PROJECT NO. PR-2020-004761
Application No. SD-2021-00032

Re: Preliminary Plat Review for Proposed Lot 1-A, Block 33, Tracts A, Unit B, North Albuquerque Acres - (8310 San Pedro Dr. NE / Anaheim Ave. NE)

Cartesian Surveys is acting as an agent for the owner and requests a preliminary plat review to dedicate right-of-way to the city of Albuquerque along San Pedro Drive NE and Anaheim Avenue NE, creating 1 lot from one (1) existing lot. The property is currently zoned NR-BP. A Sketch Plat review meeting was held on December 9, 2020, project number PR-2020-004761. Here, we address the preliminary plat comments from February 18, 2021 as the DRB provided.

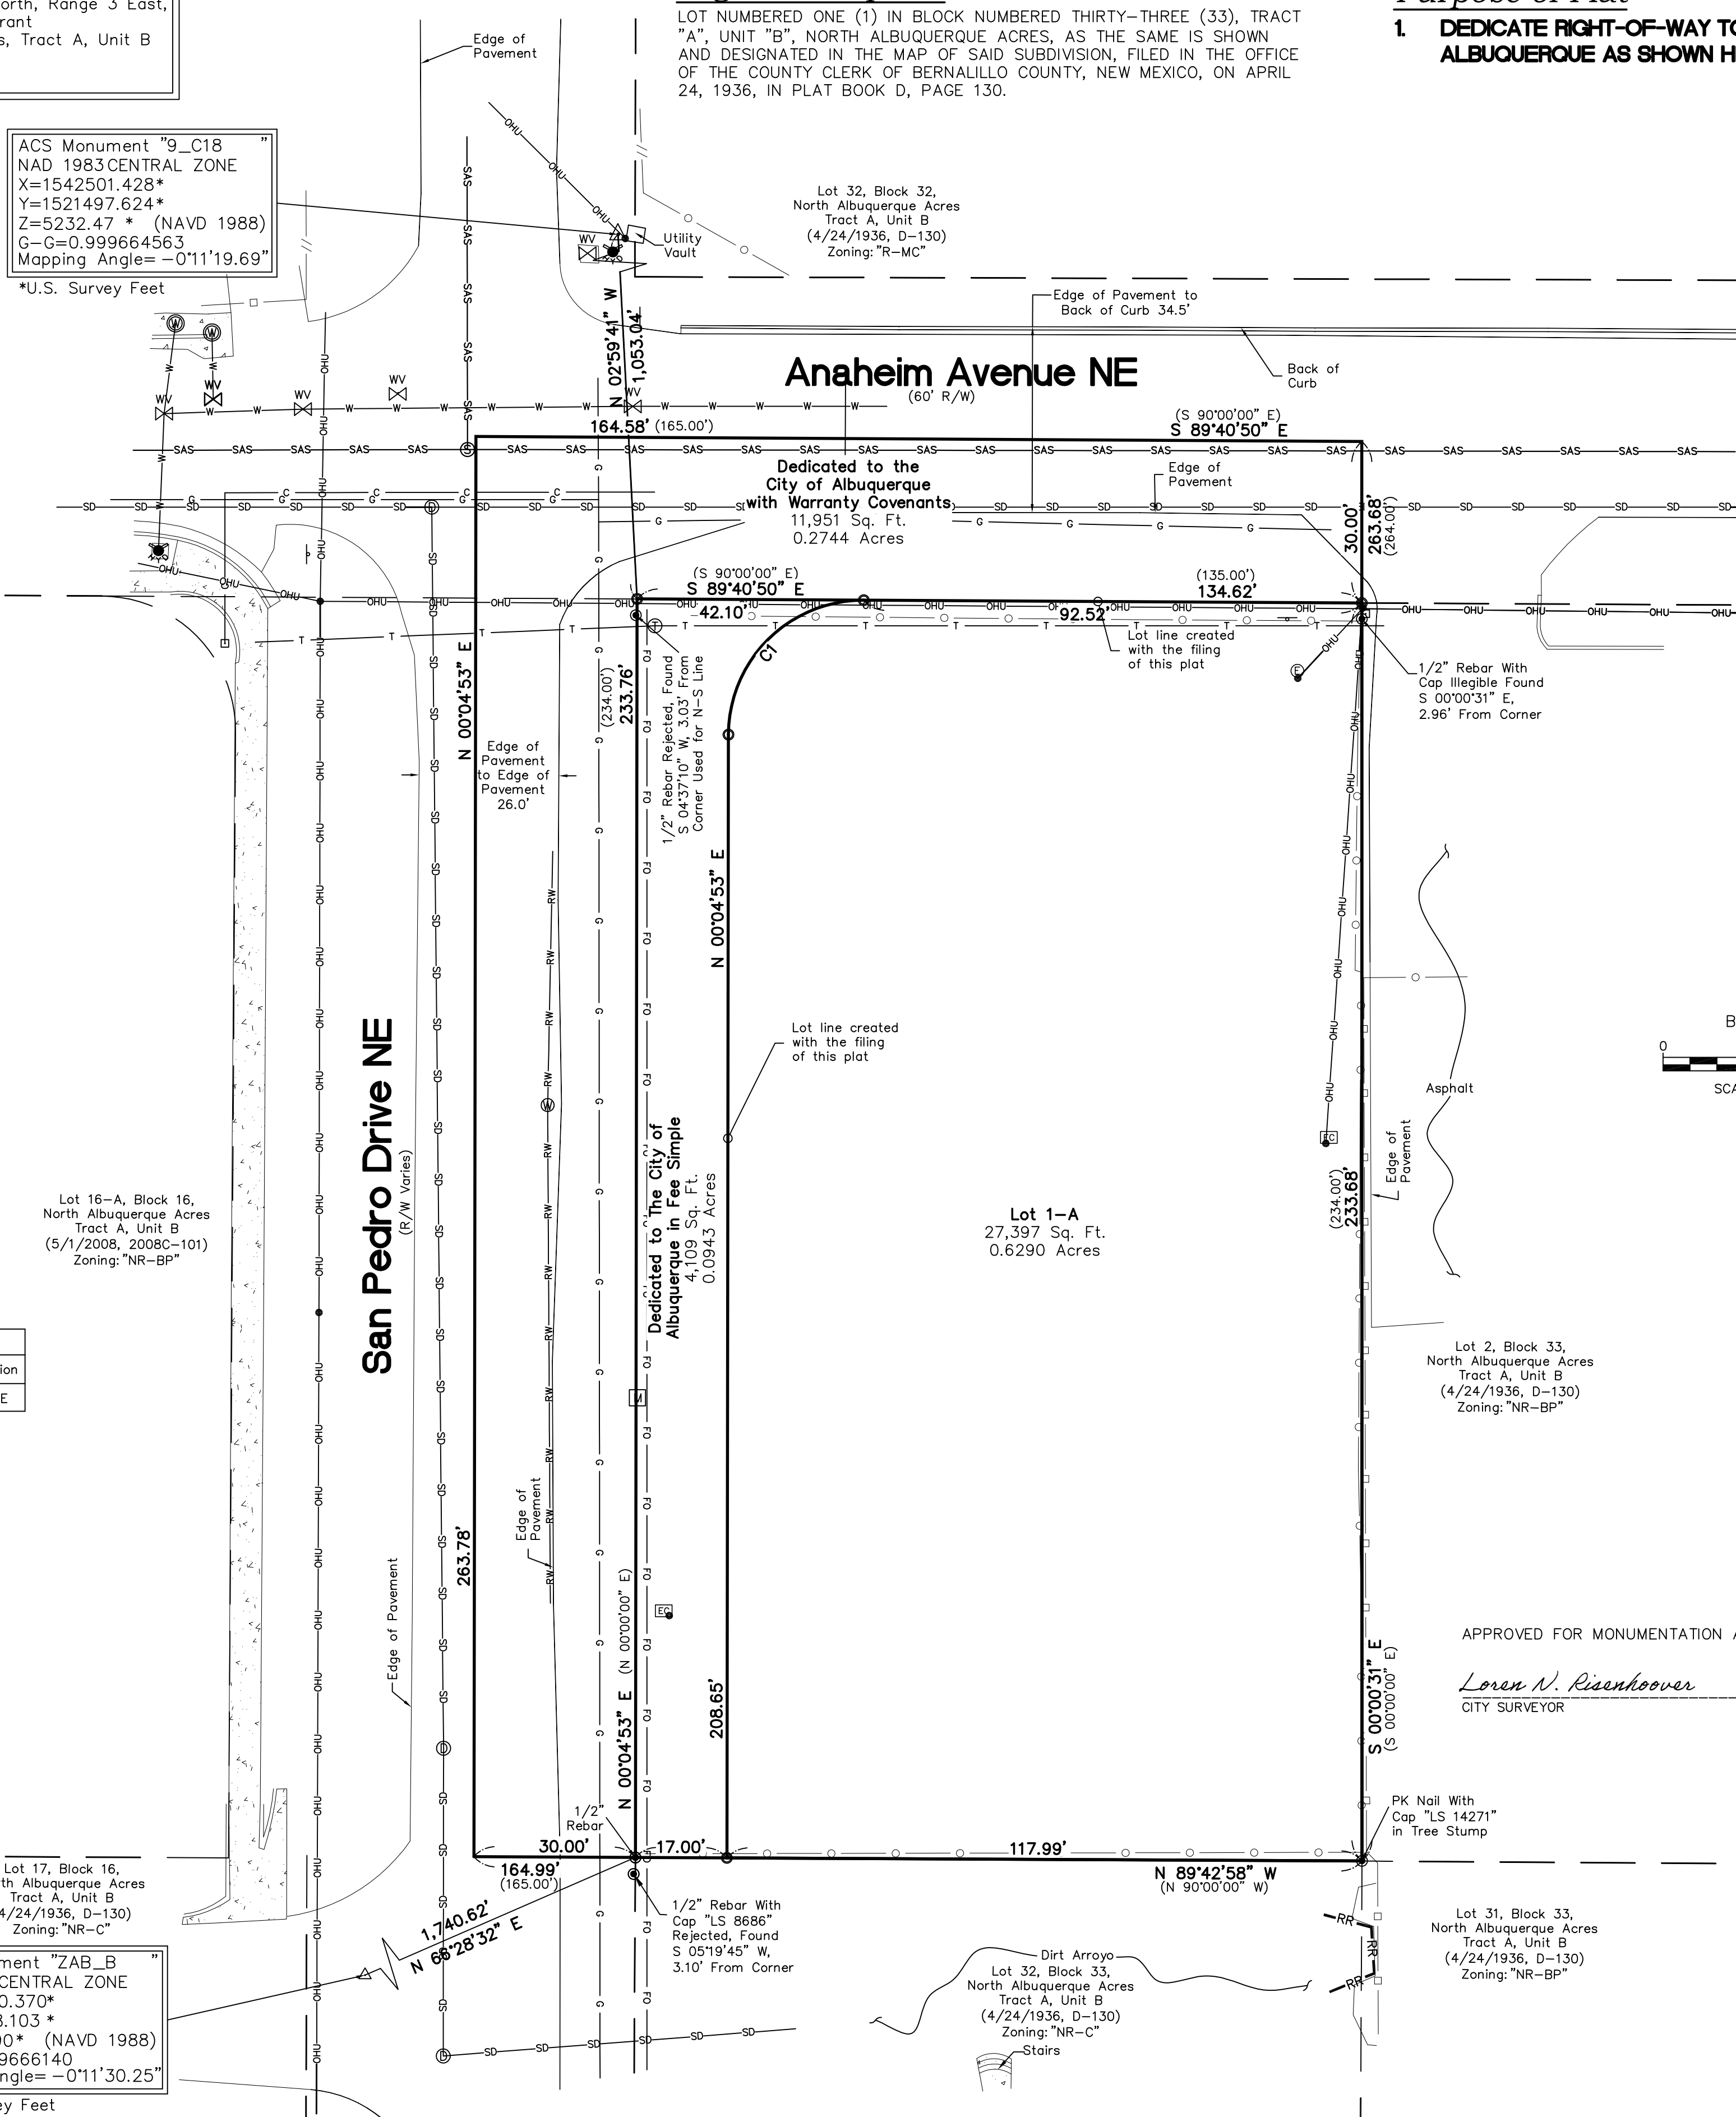
If right of way dedication is required a plat will be required to show that.
<http://www.cabq.gov/planning/boards-commissions/development-review-board>
see the DRB webpage for application details

Noted, dedication is shown on Preliminary Plat

Sheet No.  
**AS101**

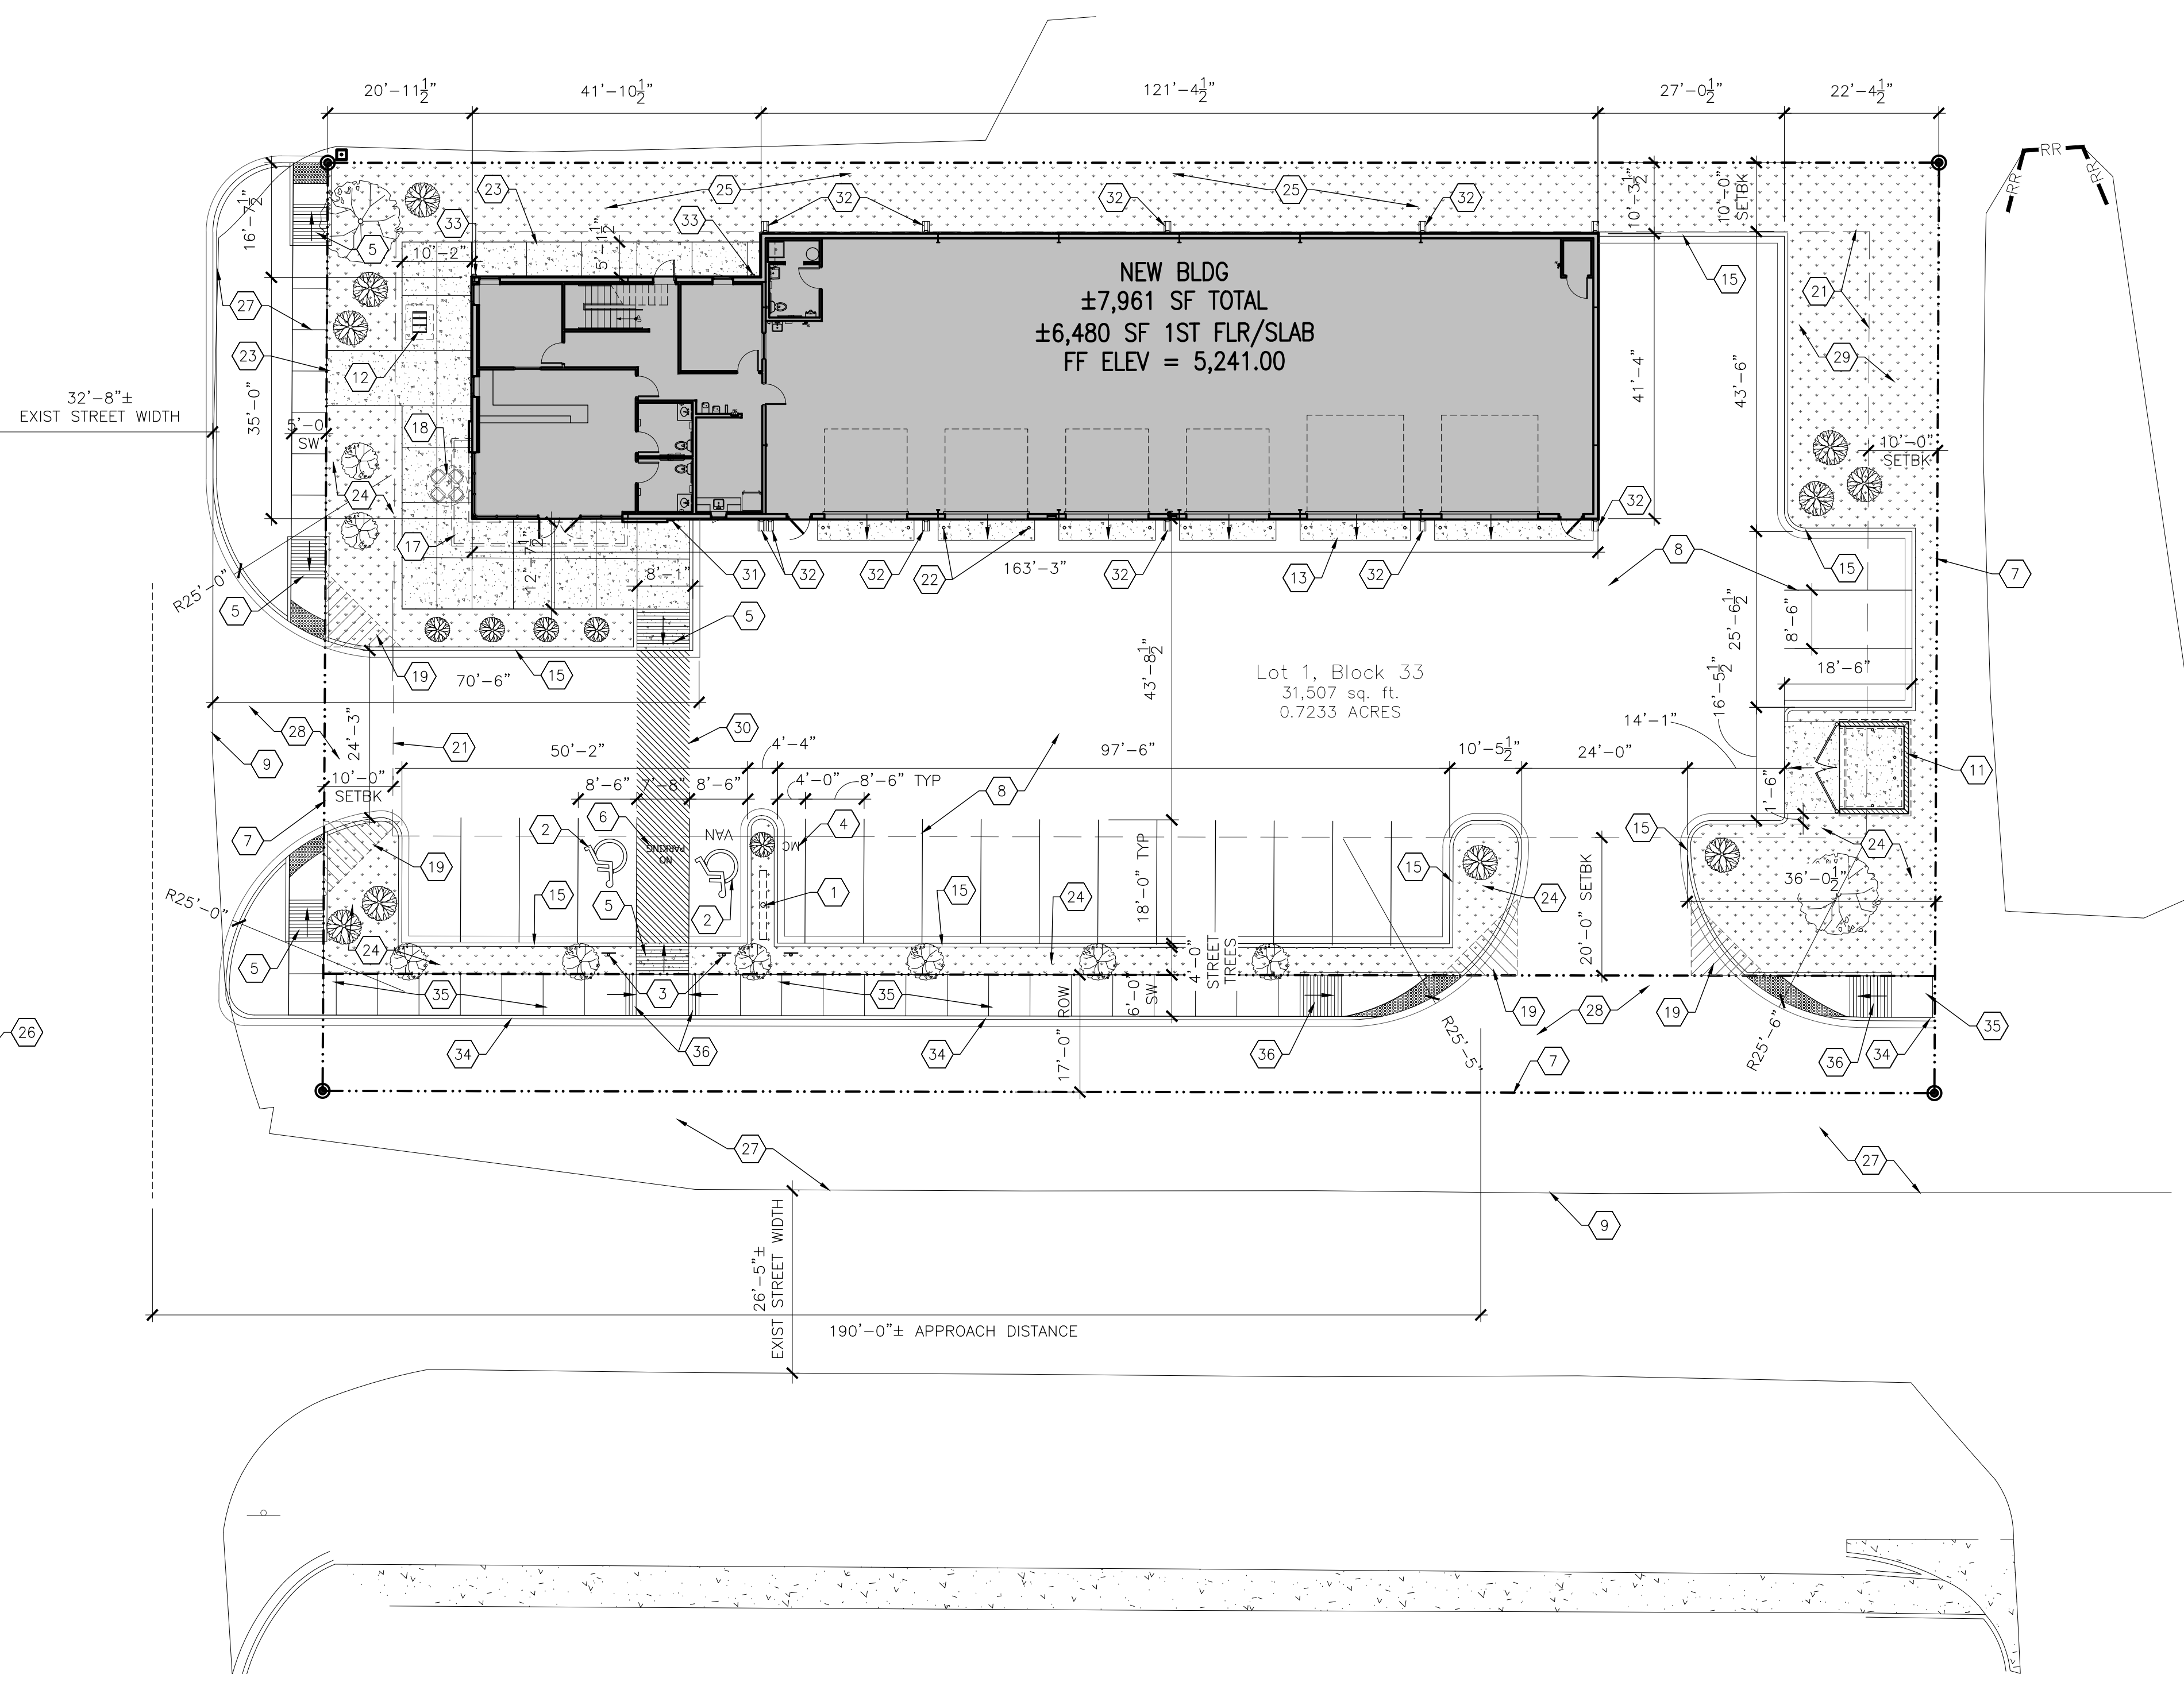
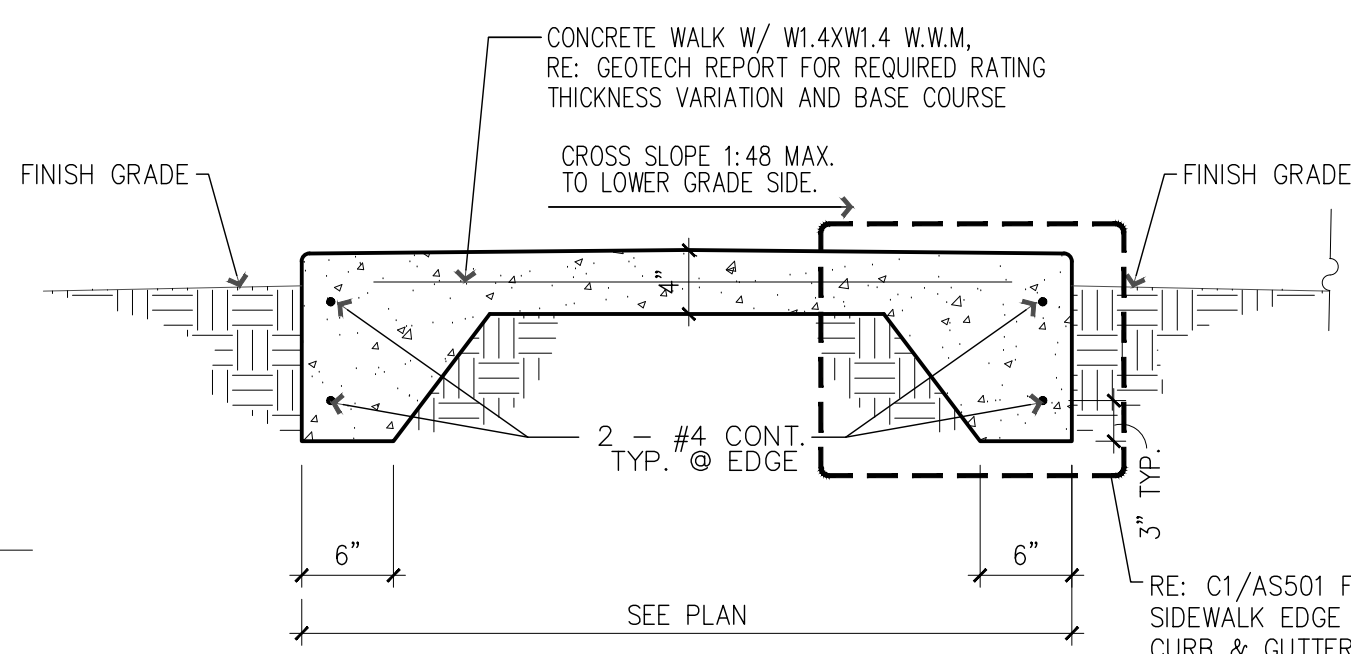
1. Add note that all roadway improvements shall be included as part of a Procedure C Agreement.

Notes on the site plat should satisfactorily designate the roadway improvements as part of a Procedure C Agreement.
